Lime Down

Solar Park

Statement of Common Ground with Environment Agency

Document Reference: EXAM/8.6

Coordinate system: British National Grid
Scale: 1:10,000 @ A3

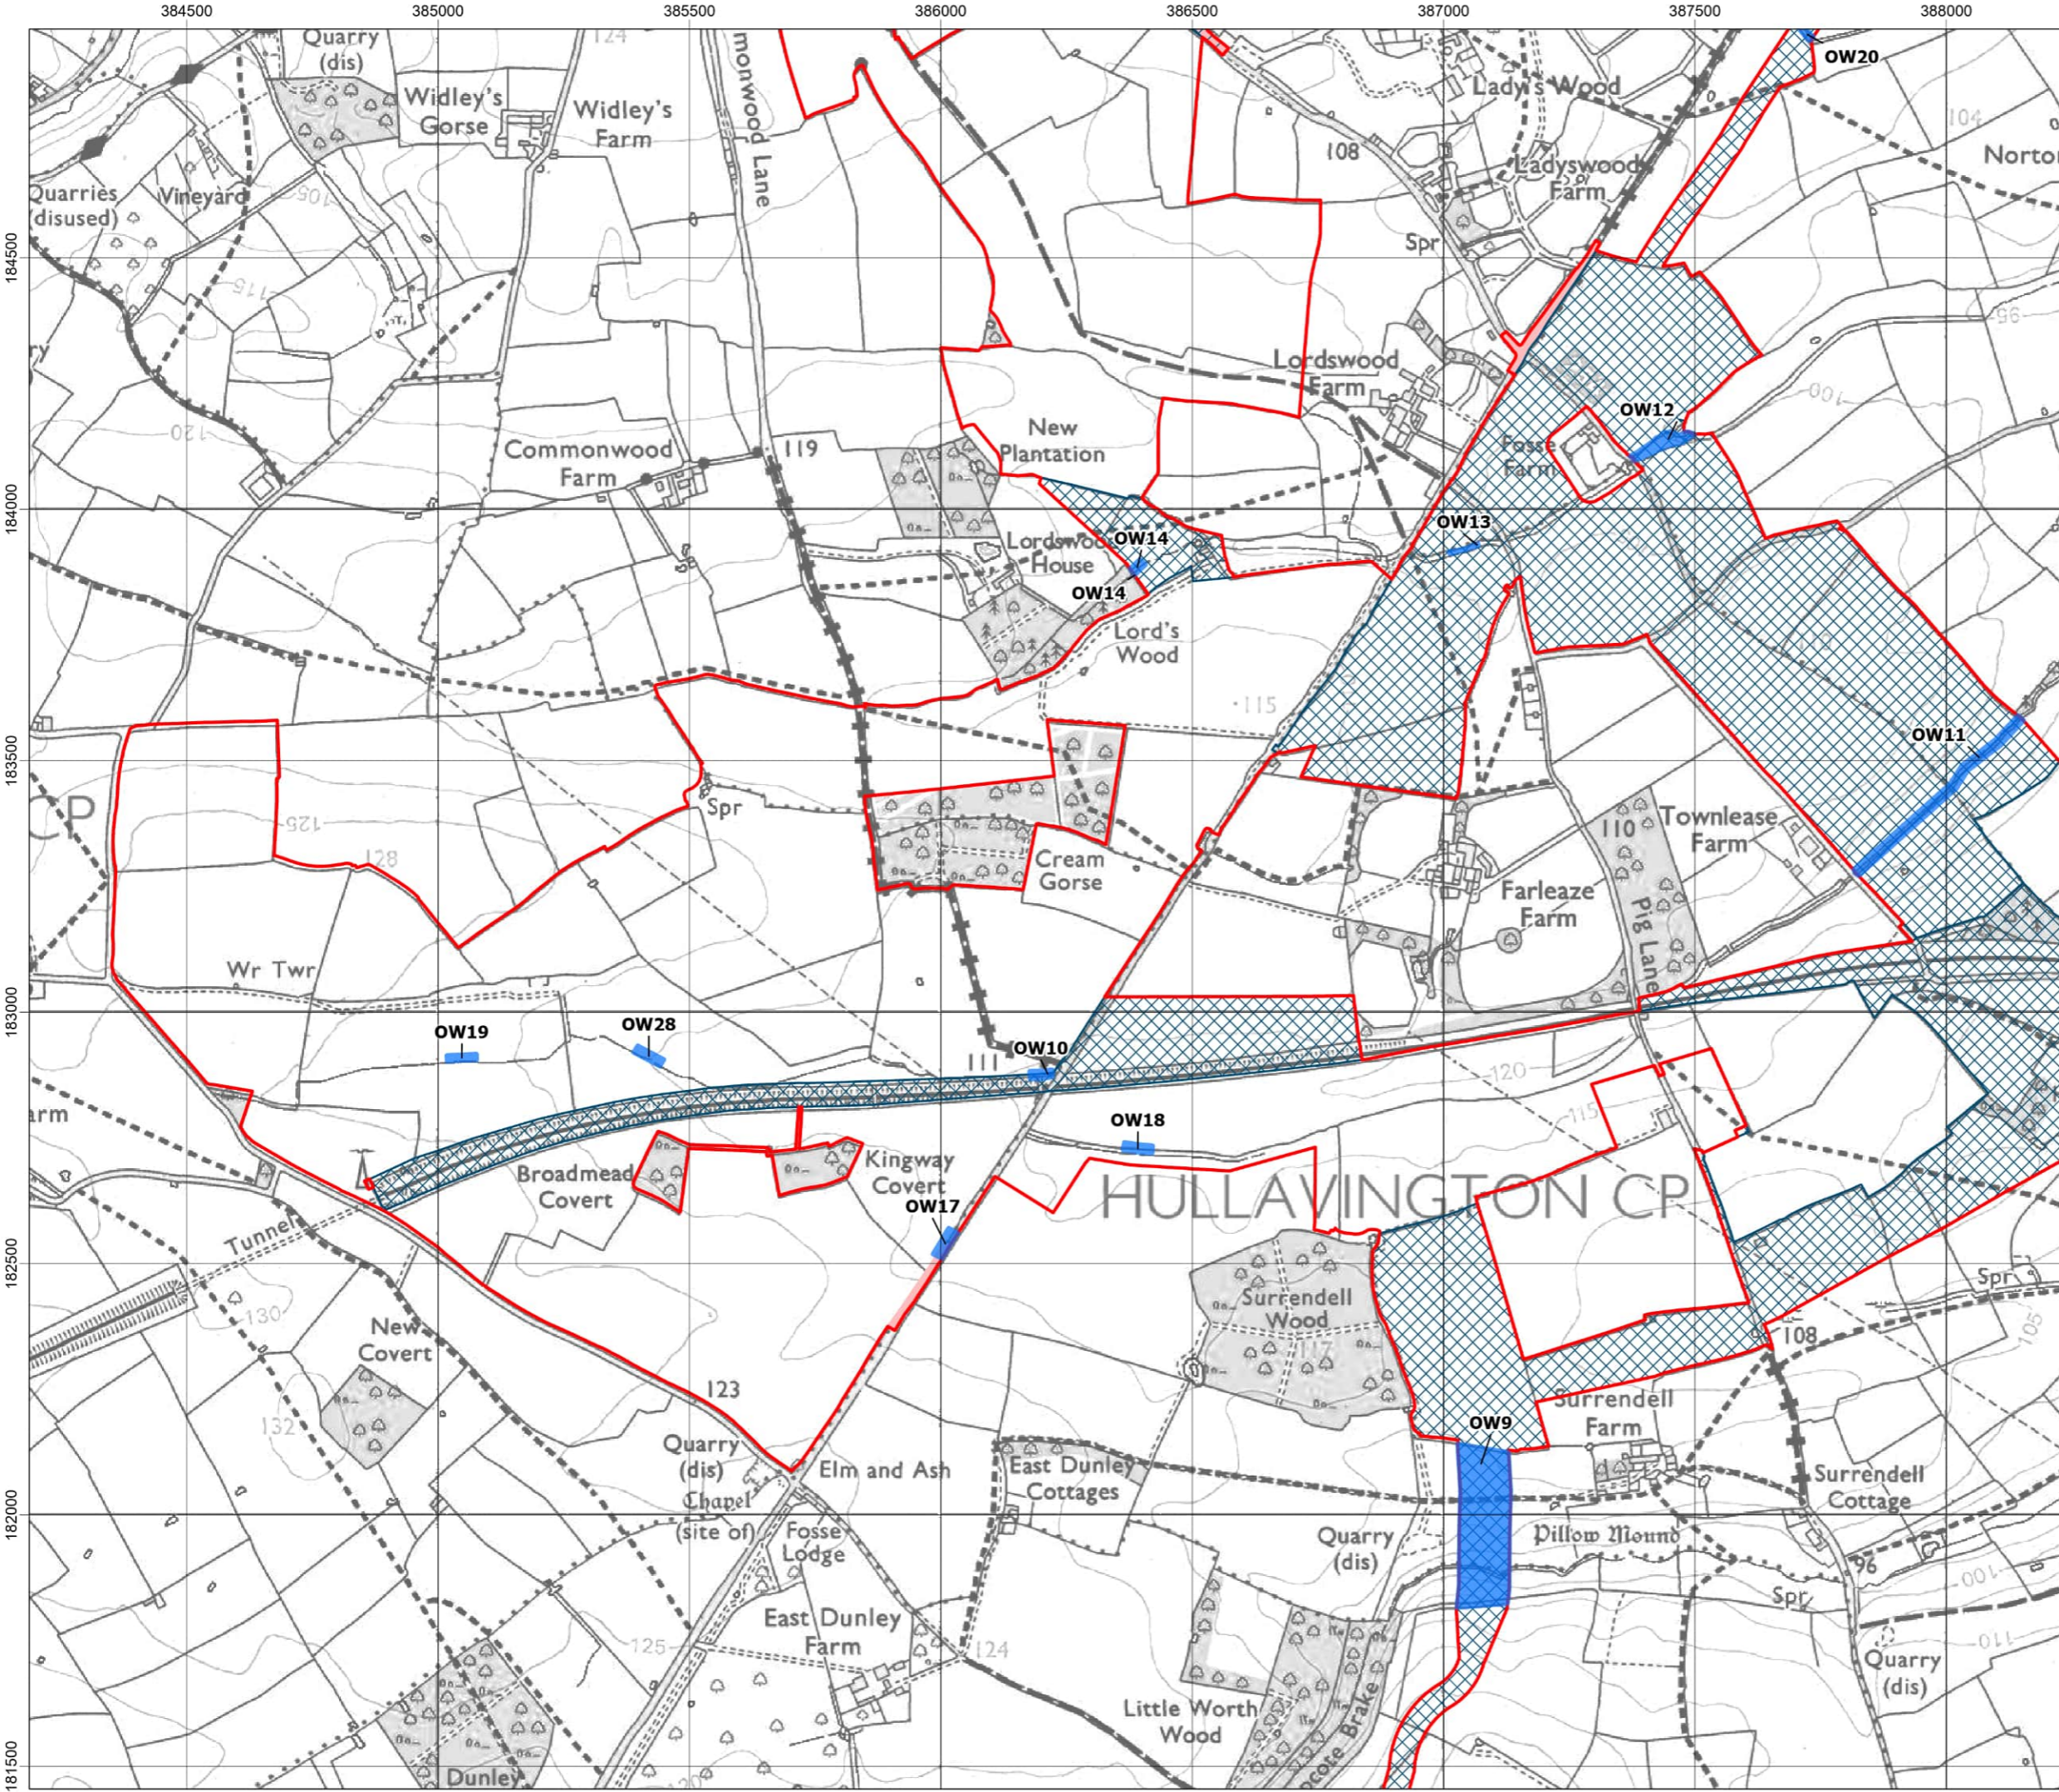
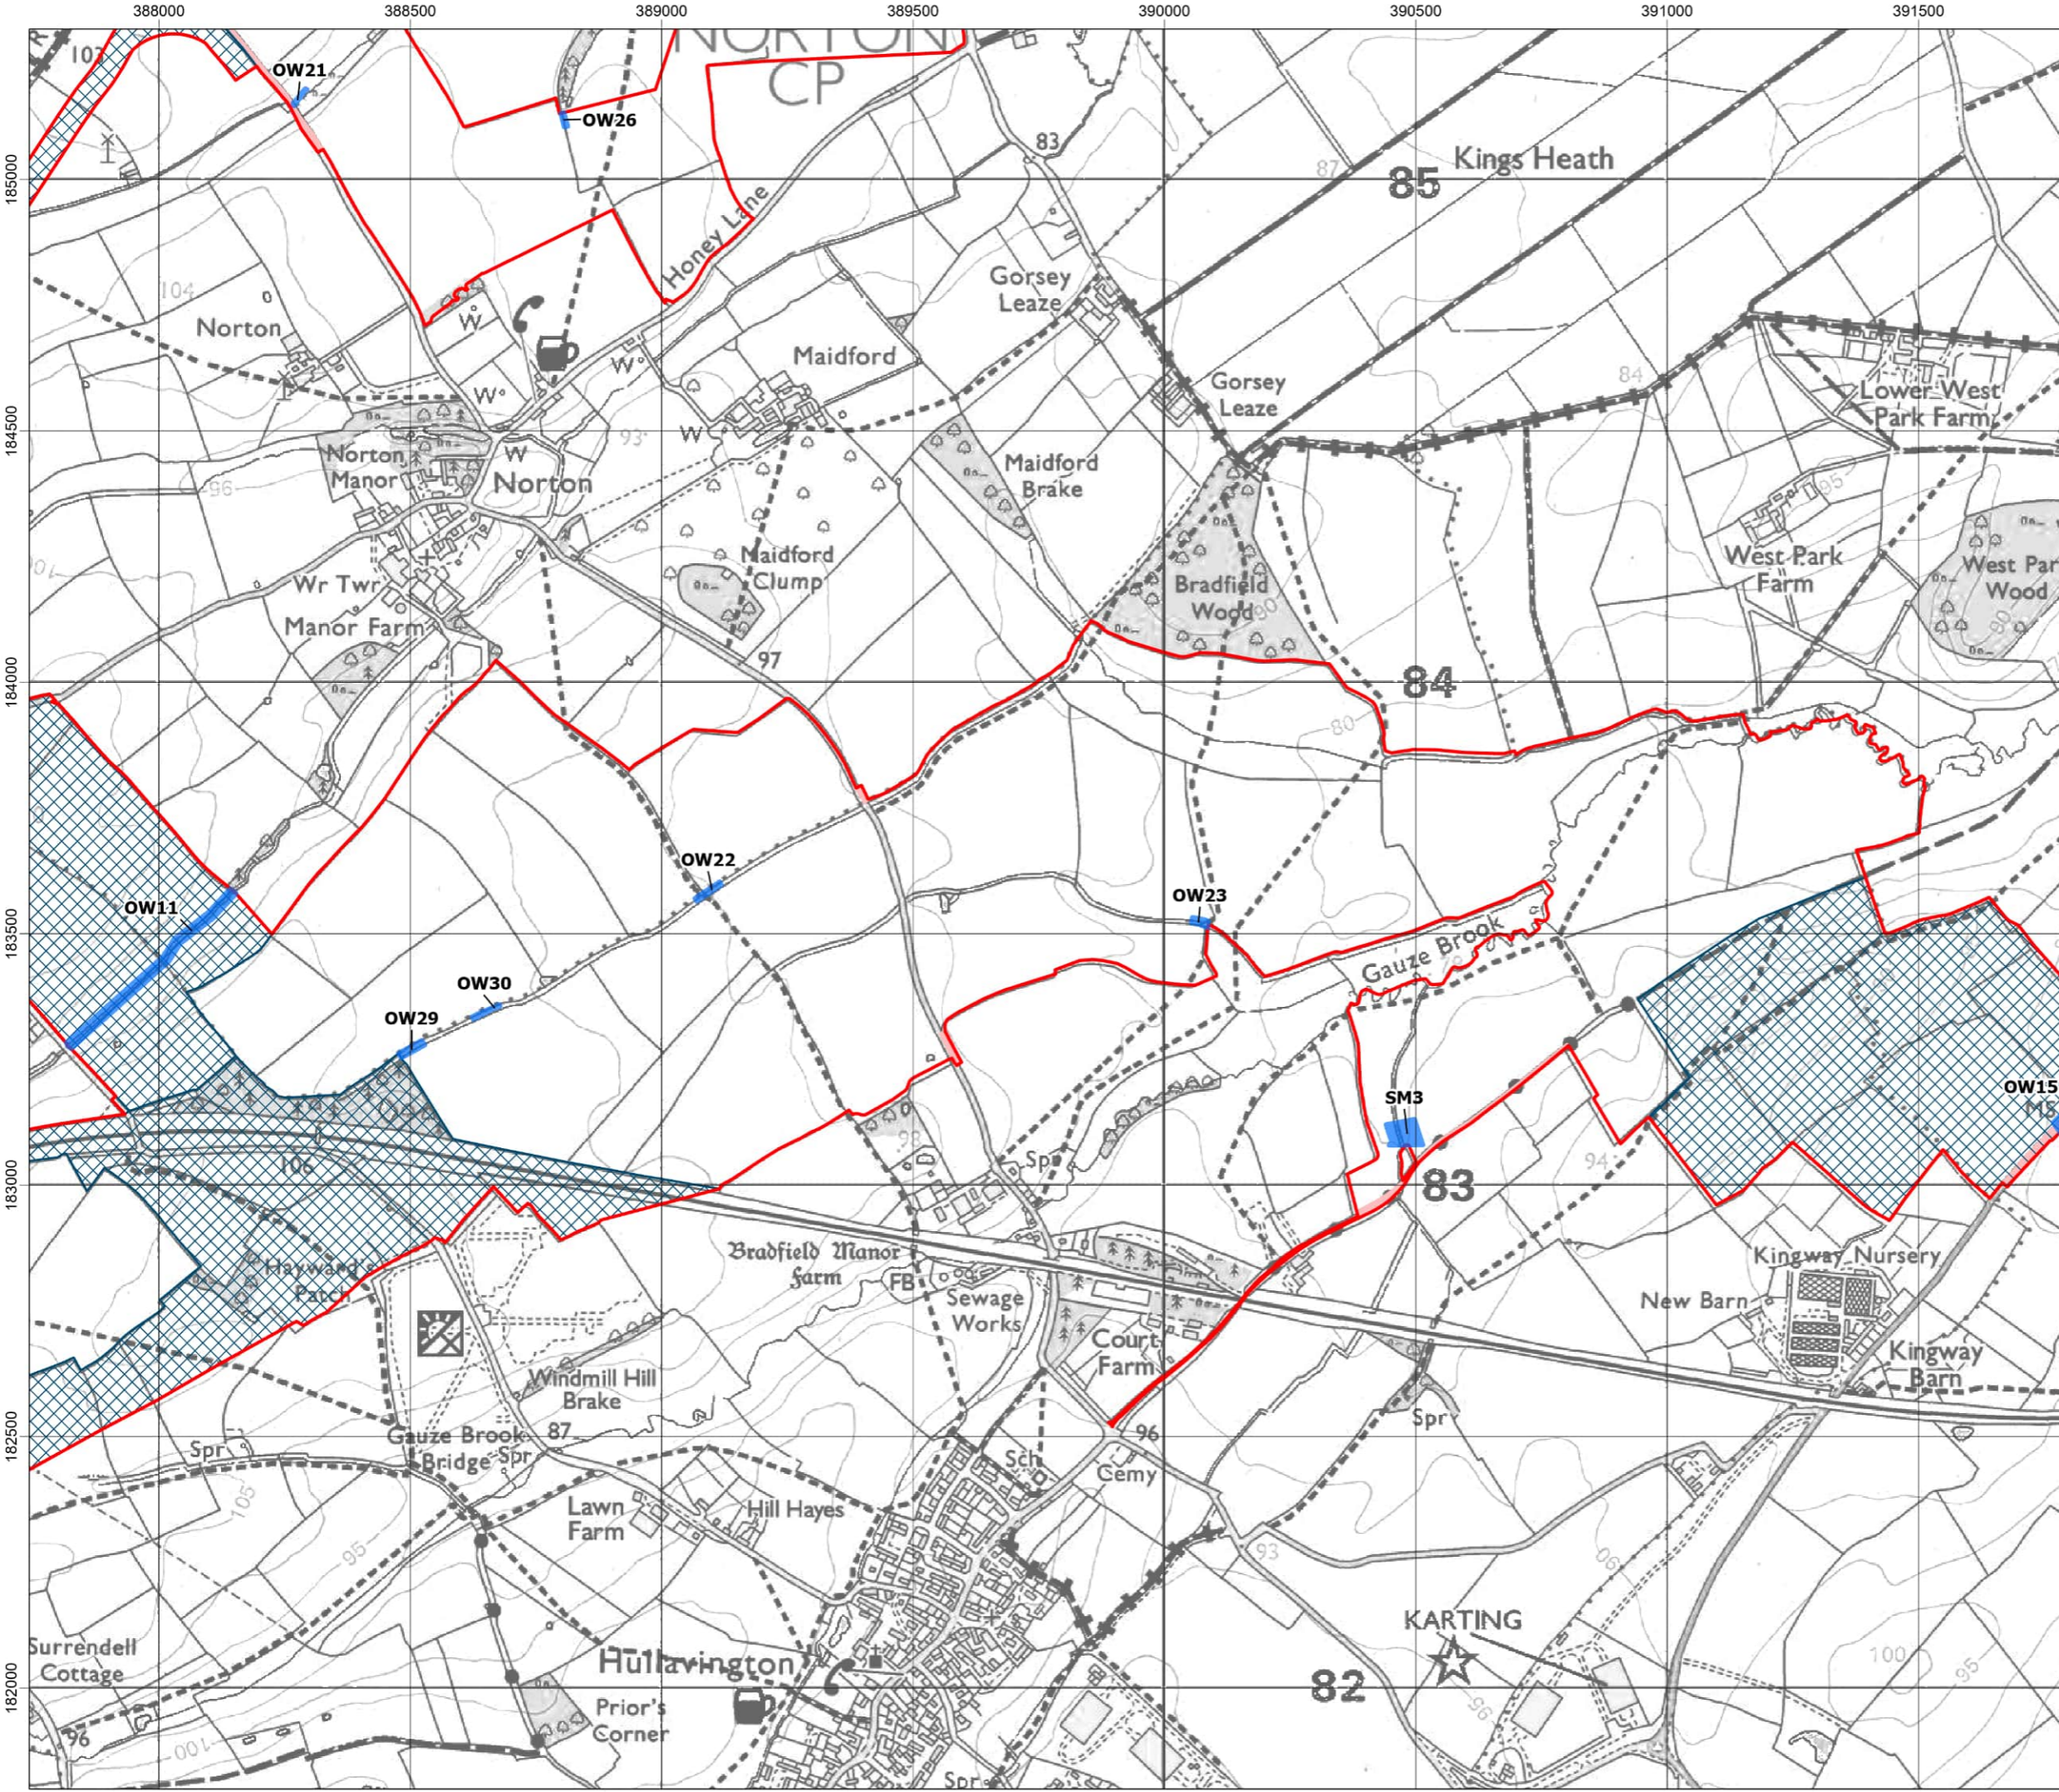
Reference	Sub-topic	EA Position	Applicants Position	Status
3.1.12	Ecological impact from watercourses crossing	<p>Due to the lack of habitat descriptions or photographs of watercourses and the reference to the use of open cut technologies on SM5 (not referenced elsewhere) in Appendix 11-1 Flood Risk Assessment and Drainage Strategy – Lime Down Covering Report; Table 5: Watercourse Crossing [APP-210], the EA is concerned that the ecological impact of these crossings has not been fully assessed and/or communicated in Chapter 9: Ecology and Biodiversity [APP-061], regarding impacts on habitats and associated species.</p> <p>Whilst we agree with the detail set out in paragraph 9.1.47 of Chapter 9 Ecology and Biodiversity [APP-061], there remains a risk that some watercourses where an open-cut method is selected could have a significant impact on fish species—not only eels and brown/sea trout. Of particular concern are crossing reference SM3 and SM5 which are both main river and may provide suitable habitat for fish.</p>	<p>A new appendix to ES Volume 3, Chapter 9: Ecology and Biodiversity was submitted at Deadline 1 which provides habitat descriptions and photographs of all watercourse crossing points, as well as the construction methodology to be used at each crossing point, for clarity.</p> <p>ES Volume 1, Chapter 9: Ecology and Biodiversity [REP1-015] has been revised to include a separate section for Aquatic Invertebrates (excluding white clawed crayfish, which is covered in its respective section), and additional text has been included on aquatic macrophytes within existing sections relating to plants. No significant residual adverse effects are anticipated for either of these species groups, and the revised Chapter was submitted at Deadline 1.</p> <p>Notwithstanding, the Applicant confirms that no watercourse crossing is proposed at SM5 and this has now been removed from the watercourse crossing schedule. This does not alter the assessed flood risk, drainage or ecological conclusions. The Applicant</p>	Under Discussion

Reference	Sub-topic	EA Position	Applicants Position	Status
		<p>The Environment Agency requires the applicant to provide a clear plan and schedule detailing extent and nature of works directly impacting upon watercourses. Provide habitat descriptions and photographs of proposed watercourse crossings and ensure Chapter 9 Ecology and Biodiversity [APP-061 assesses the impact of these, with other documents updated as appropriate.</p> <p>This would provide confidence that the chosen crossing type is appropriate.</p>	<p>will update the relevant application documents as set out above.</p>
